From: Laura Gibbons
Sent: 14 September 2018 09:19
To: Planning.Responses
Subject: RE: Planning Consultation on: R/190/18/PL

Engineers Comments Regarding Surface Water Drainage

APPLICATION R/190/18/PL

Site Address: St Marys Close Hurst Road Rustington BN16 3AP

In Situ Percolation Test

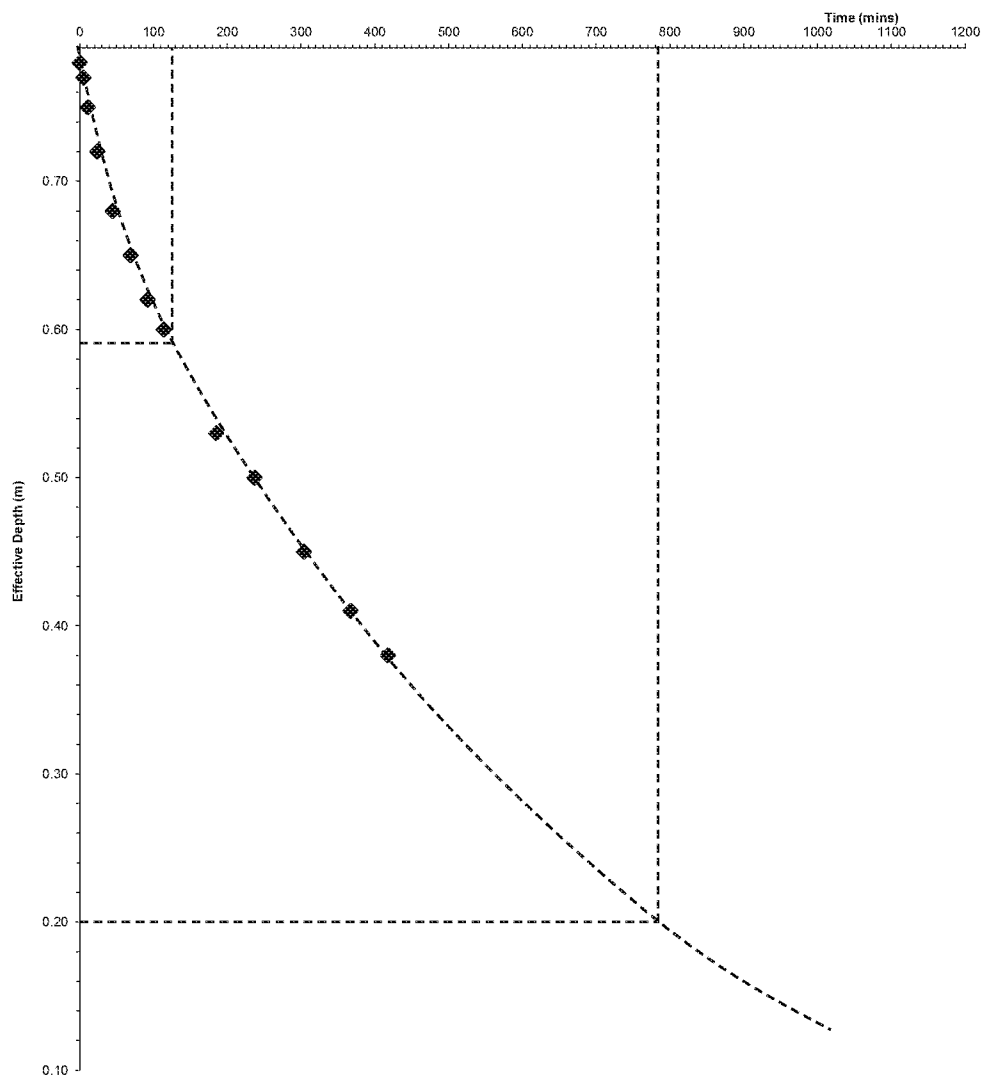
One set of infiltration testing results were provided, this test was completed in the summer and at 2.8m depth. We will need to see the results of winter percolation tests that are completed at the designed depths. I.e. shallow tests where permeable paving is proposed. And then tests at a depth less than 2.2m below ground level for the trench soakaways.

Drawing Title			
Indicative Drainage Layout			
Drawn	Checked	Scale	Page Size
KN	KN	1:250	A1
Job No.	Drawing No.	Revision	
ES1702	502-03	A

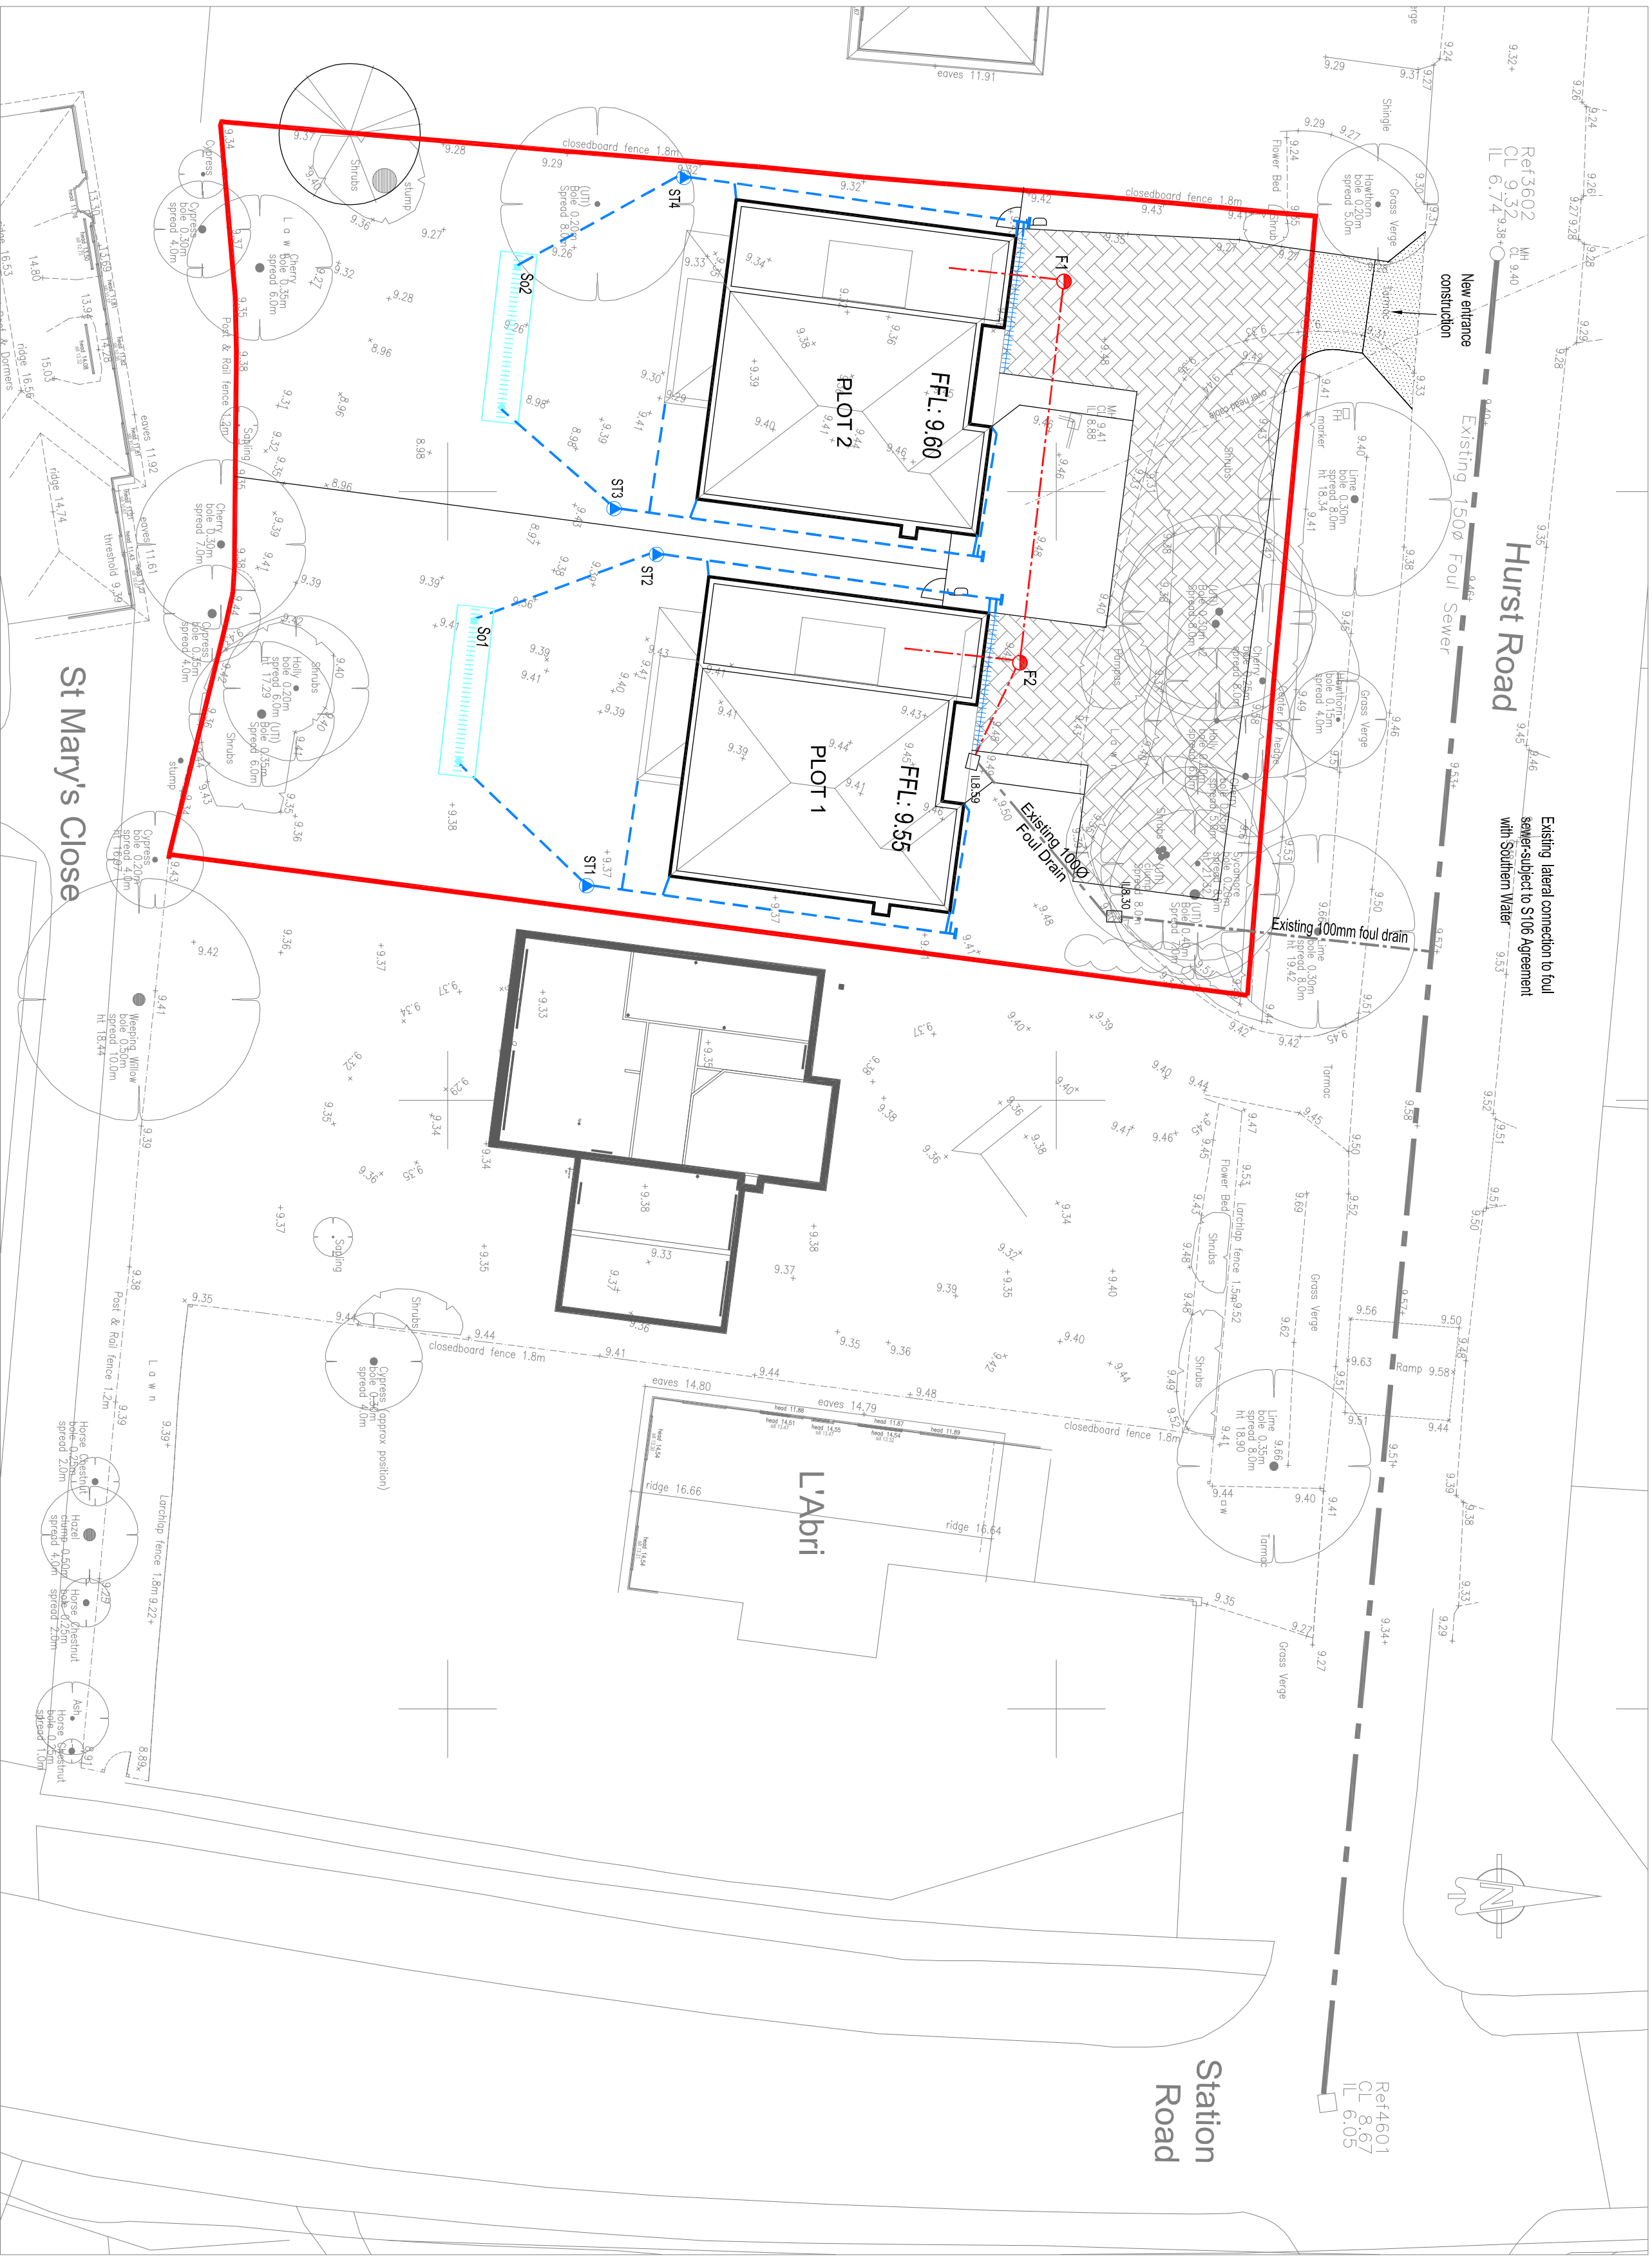
To discharge the condition the applicant will need to provide; infiltration test results, calculations evidencing there is sufficient capacity in the system, more detailed layout drawings, and construction detail drawings.
